From: Ian Brewster
Sent: 09 November 2011 17:17
To: Eve Hearsey
Cc: Katherine Rawlins; Joe Russell-Wells
Subject: RE: Condition AW/237/11/DOC

We have a discharge of condition application (above ref) the condition no. 4 relates to the requirement for a method statement regarding the storage of plant etc to preserve the health of trees.

CONTRACTOR'S SITE COMPOUND drw.

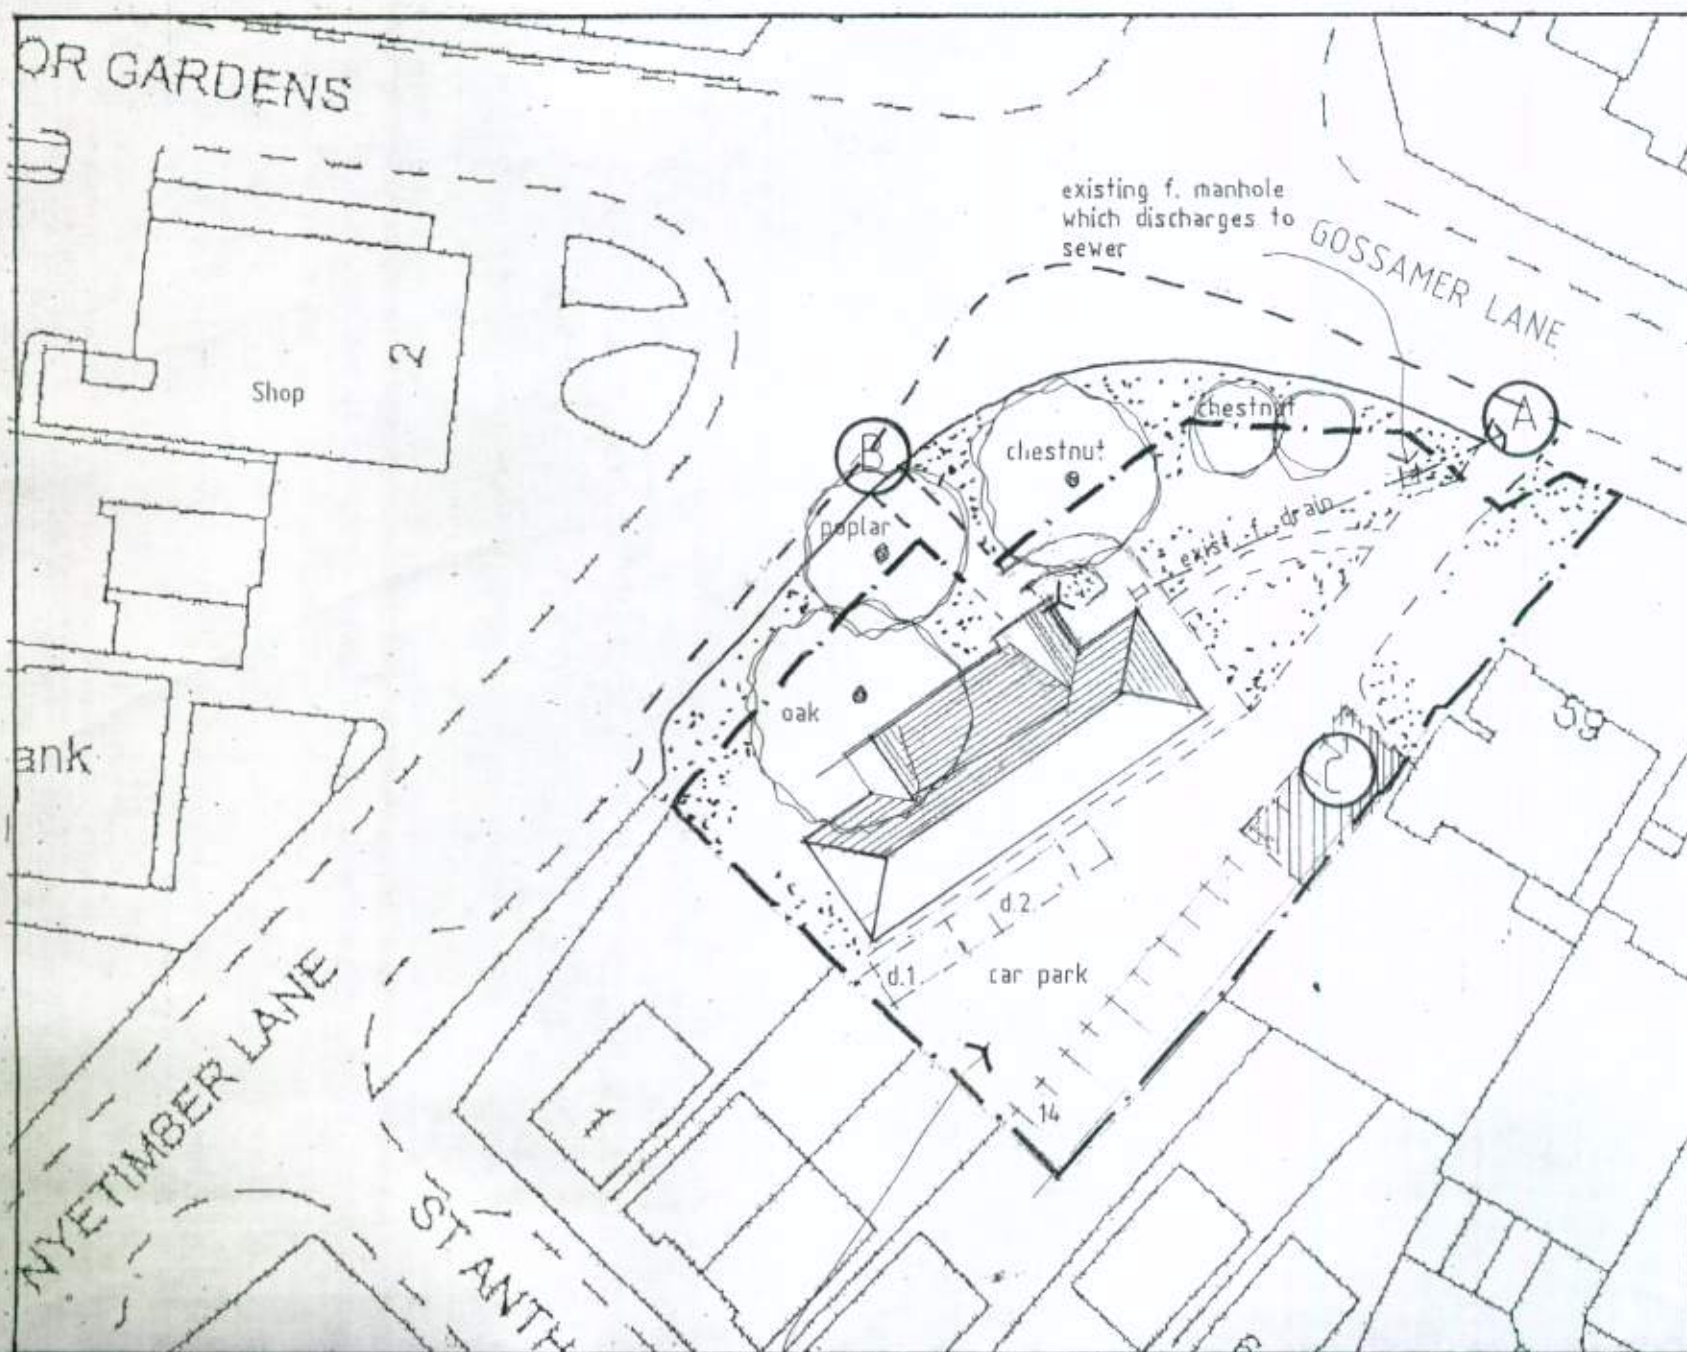
the storage of plant within the Area C as marked on the Studio 5 architects ltd. (job no. 10.530) plan within the car park is at a sufficient distance to not impinge adversely upon the health of the three protected trees which are located to the north west of the Church. I therefore accept that an appropriate area for plant and storage has been identified according to Condition 4:
